Your reference: SSD 5346; SSD 5347; SSD 5349
Our reference: ECM 3804935
Contact: Robert Craig
Telephone: (02) 4732 7593

State Significant Development Applications for Stages 2B and Stage 2C (SSD-5346), Stage 2D (SSD-5347) and Stage 3B (SSD-5349) of the North Penrith Mixed-Use Development.

Council officers have reviewed the Environmental Impact Statements and accompanying plans and reports submitted with the applications. Comments and recommended conditions of consent in relation to key assessment issues for the proposals are detailed in Attachment 1 to this letter.

NORTH PENRITH  
STAGE 2D  
ROAD LONGSECTIONS  
SHEET 1

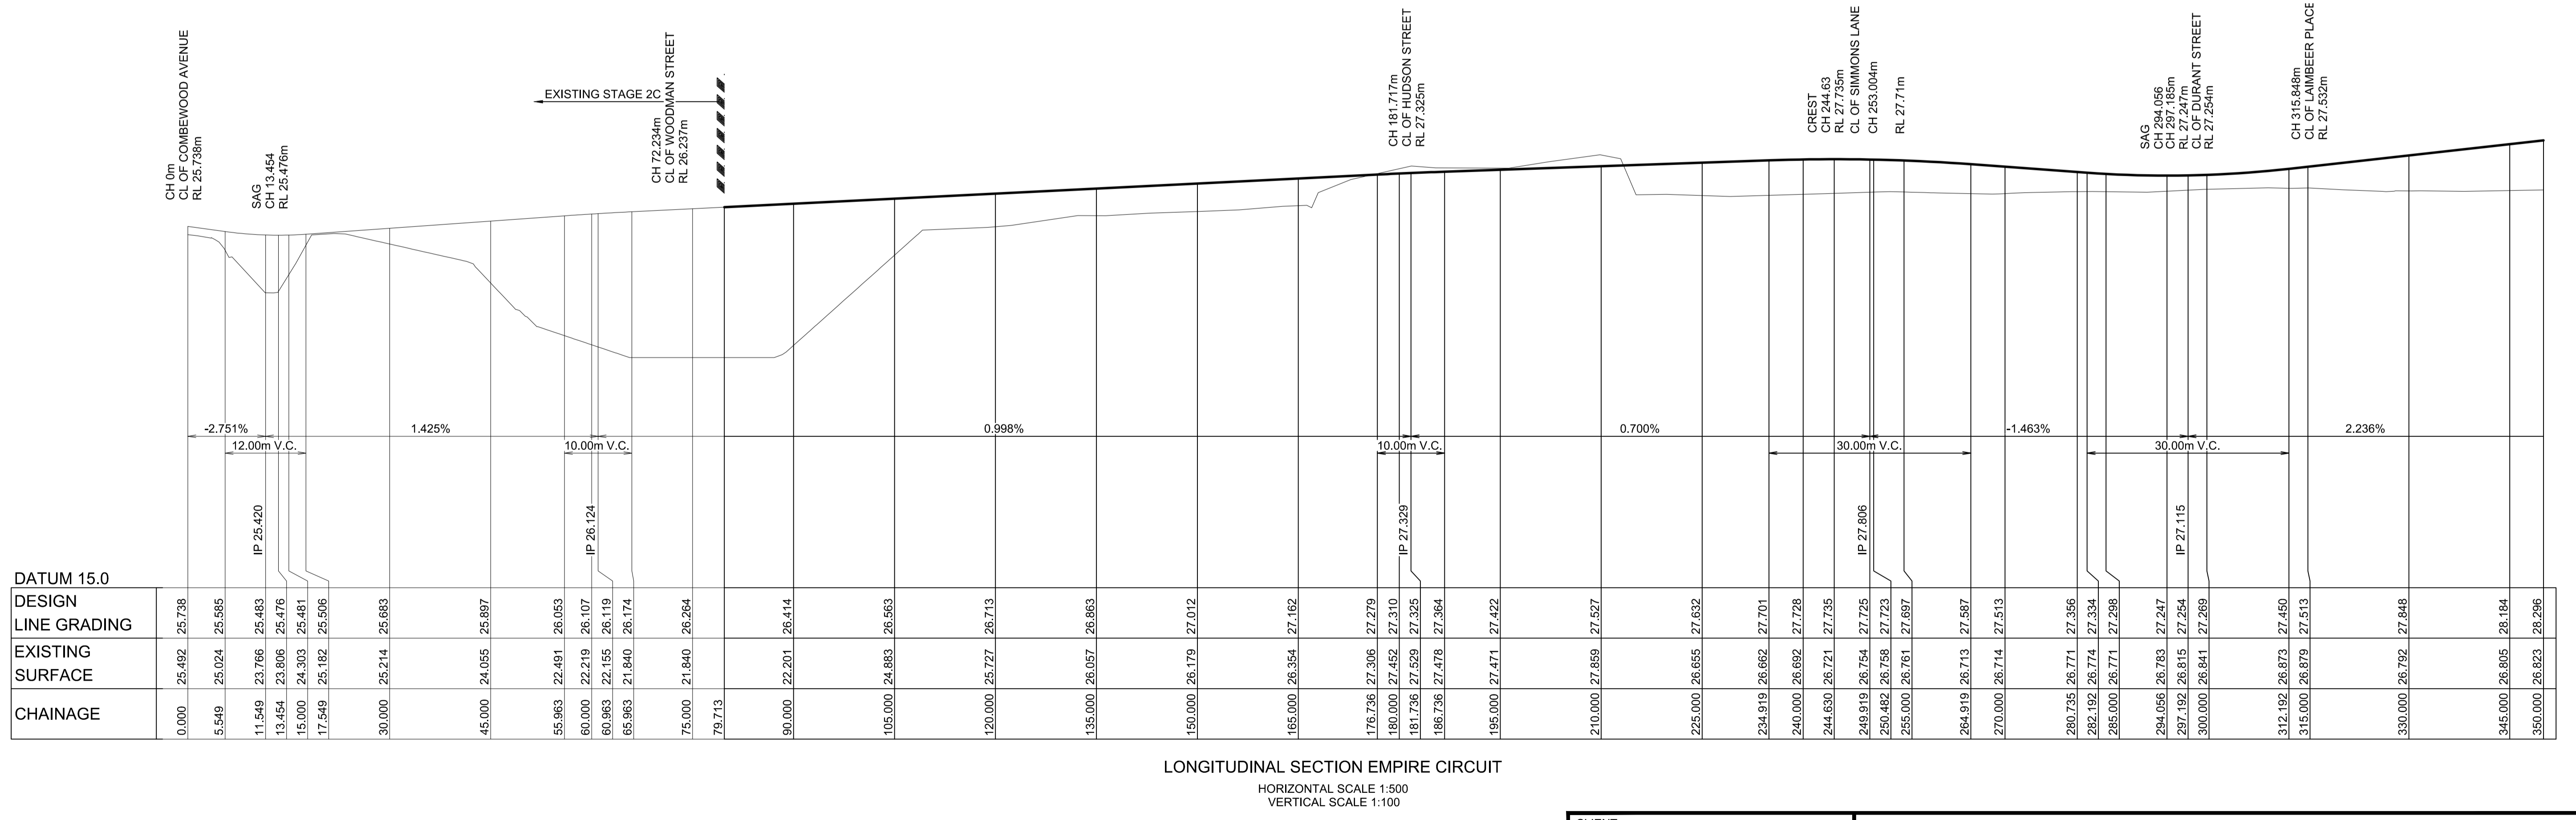
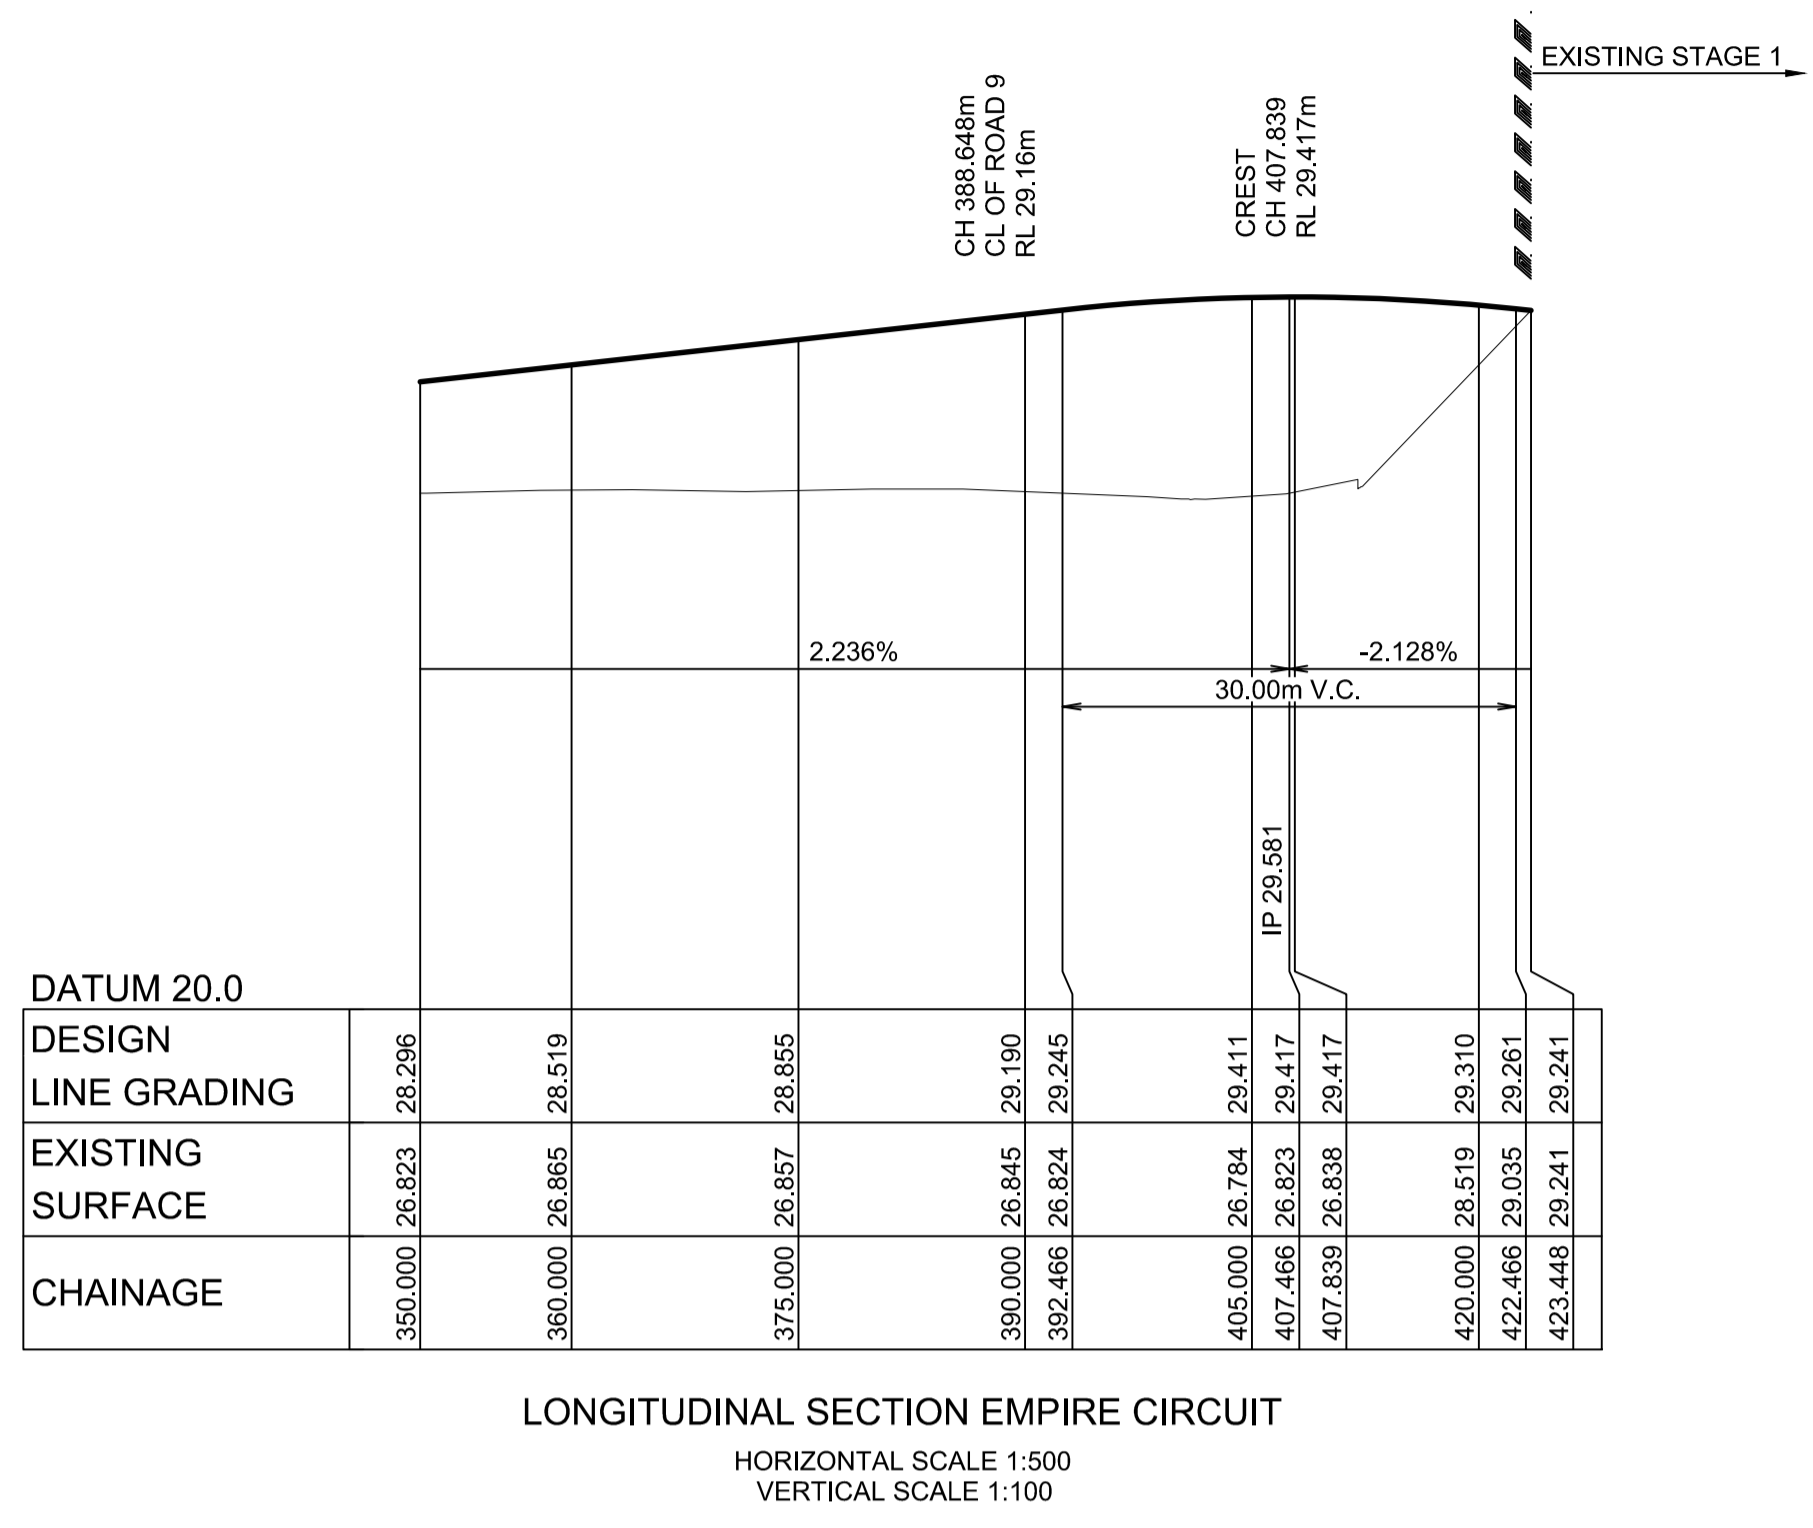
- A maintenance plan shall be provided for any Construction Certificate approval for landscape elements for general maintenance and asset renewal purposes. Costs should also be included.
- Street cross sections are inconsistent with Council standards. The inconsistency relates to 1.2m versus 1.5m path widths in narrow verge widths (3.6m). Council's standard is 1.5m however this path in a 3.6m verge means there is insufficient space for street trees. Also, there are both 3.8m and 3.9m verge widths.
- Fencing details should be provided. Council requires assurance that opportunities for graffiti are minimised and surrounding and streetscape amenity is not compromised by the height and scale of fencing.
- Council generally supports a mix of native and exotic species. With the over-dominance of exotics proposed, Council requests more native species be included in the
